F19/69

21 February 2019

**Parramatta Leagues Club Hotel (SSD 8800) - 1 Eels Place, Parramatta**

## ATTACHMENT 1

6/12/2018 11:19:29 AM

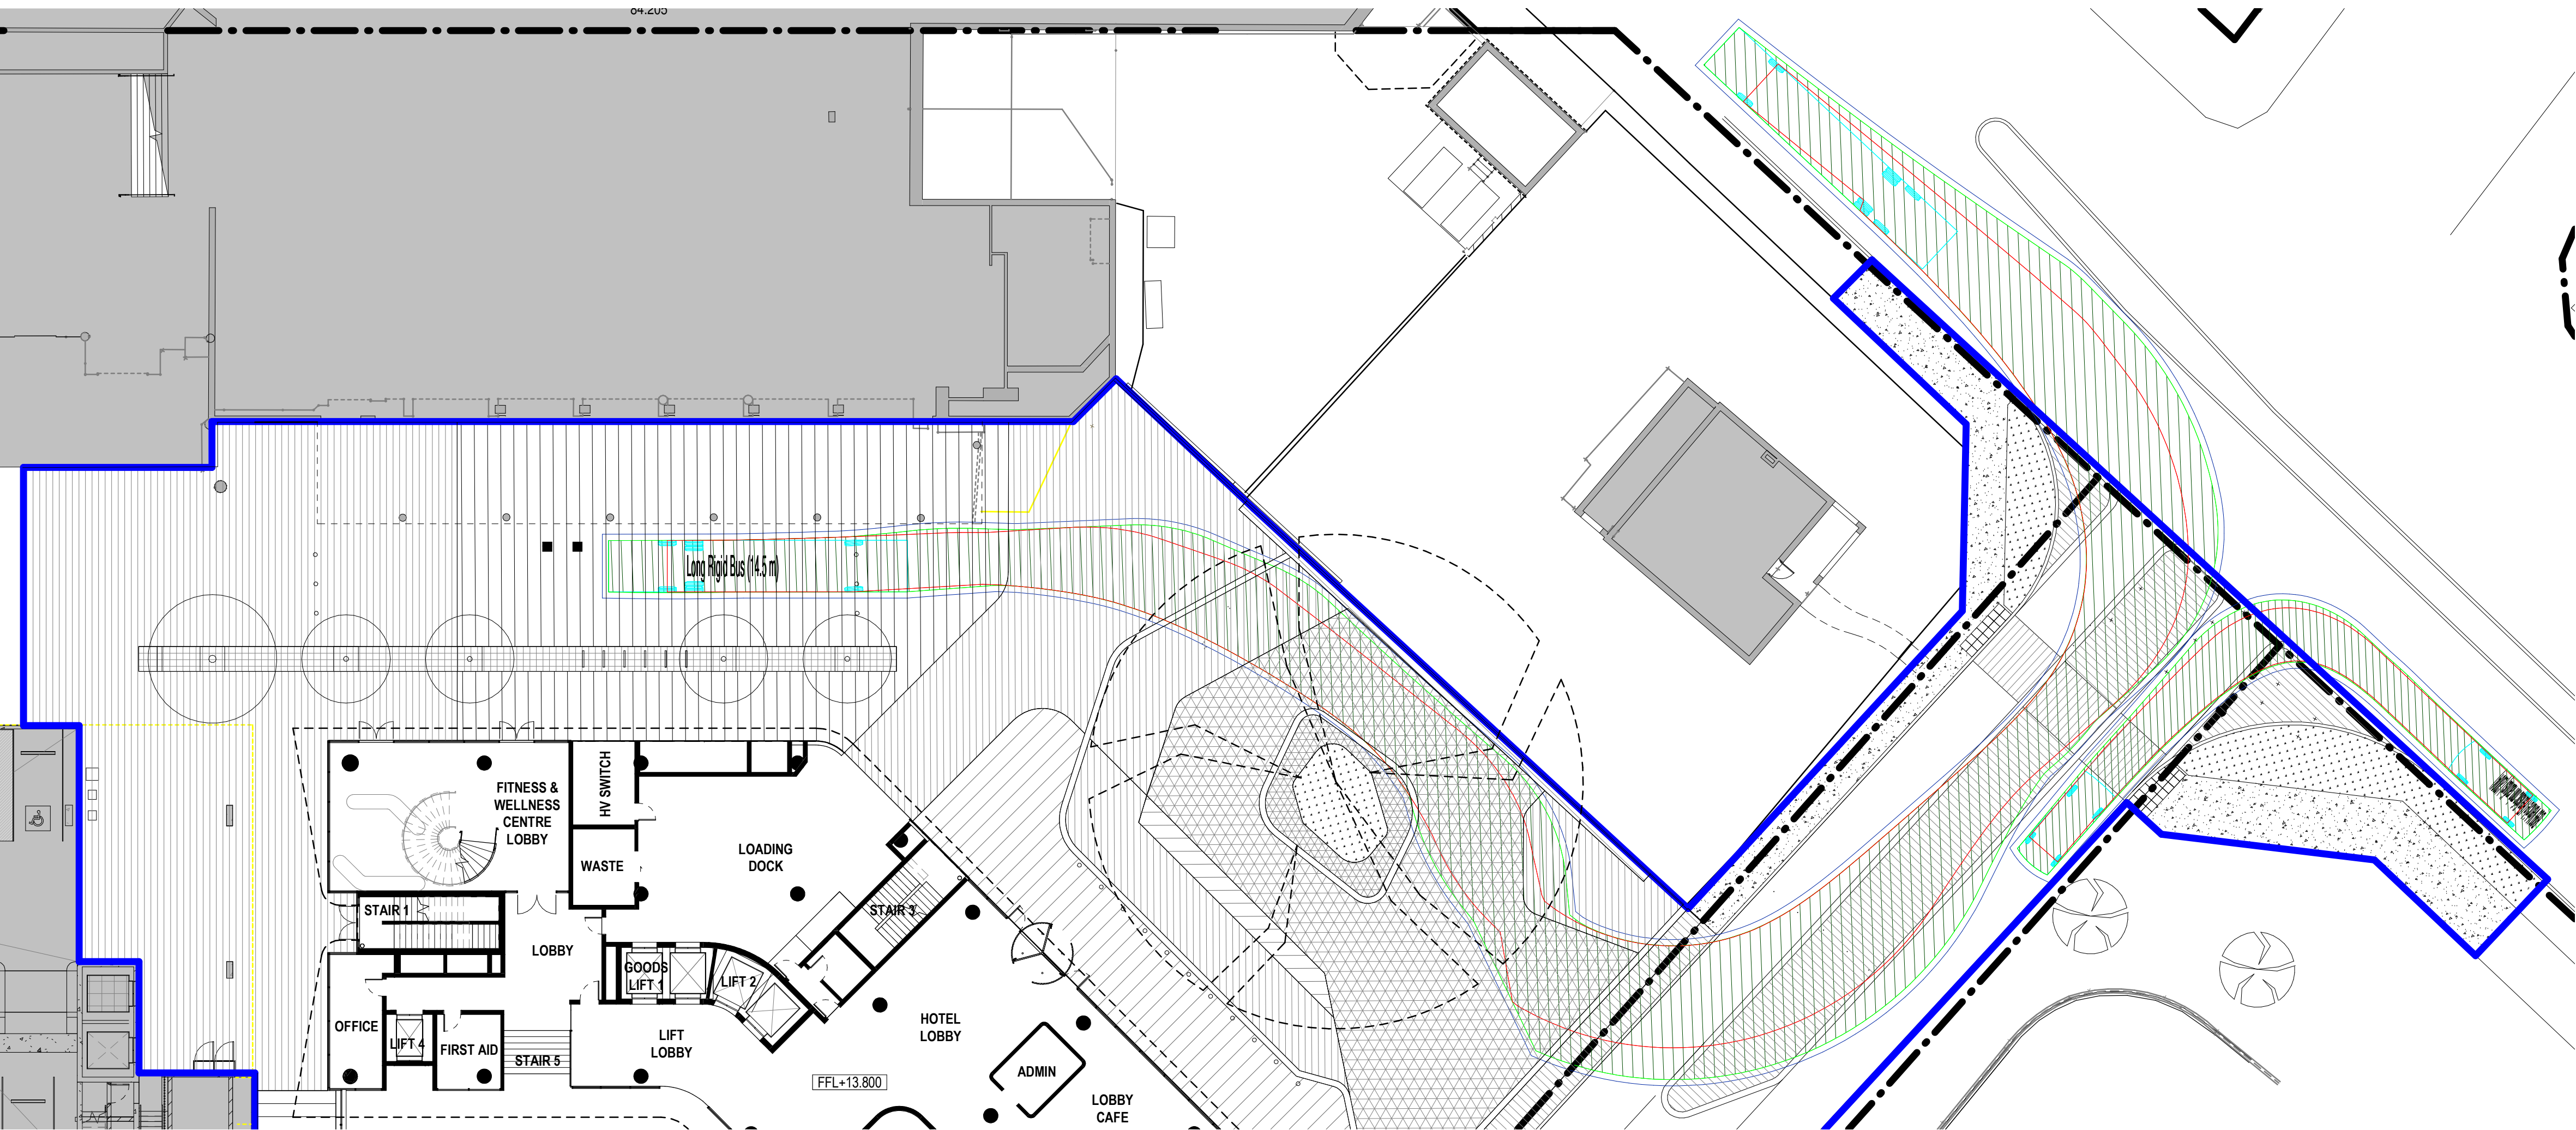
As is acknowledged in the Parramatta Leagues Club Hotel Development Application (DA), it is currently the intent that the access road that leads from O'Connell Street to the Western Sydney Stadium Northern Car Park is Venues NSW land and is a critical part of the operations of the Stadium.

However, SSD 8800 proposes that this road is used for vehicular access to the Hotel:

***Access at all times is critical and should not be comprised by introducing traffic from hotel clients and service providers. Any utilisation of that road for activities not related to stadium event bump in/out and during events that will cater for up to 30,000 patrons is simply not feasible.***

With more than one event per week on average, attracting between 15,000 and 30,000 patrons each, in addition to a significant calendar of non-event day functions, Venues NSW do not believe it is possible for the Northern Car Park Access Road to facilitate the additional traffic generated by any use for Hotel operations.

It is the view of Venues NSW that **all access** for hotel guests, tenants, staff and service providers be via Eels Place and that the Northern Car Park Access Road is preserved exclusively for the Stadium and associated uses.

Venues NSW strongly objects to the DA proceeding on the basis of any proposed use of the Northern Car Park access road.

The PLC's plans are re-drafted on the basis of all Hotel traffic entering and leaving exclusively via Eels Place.
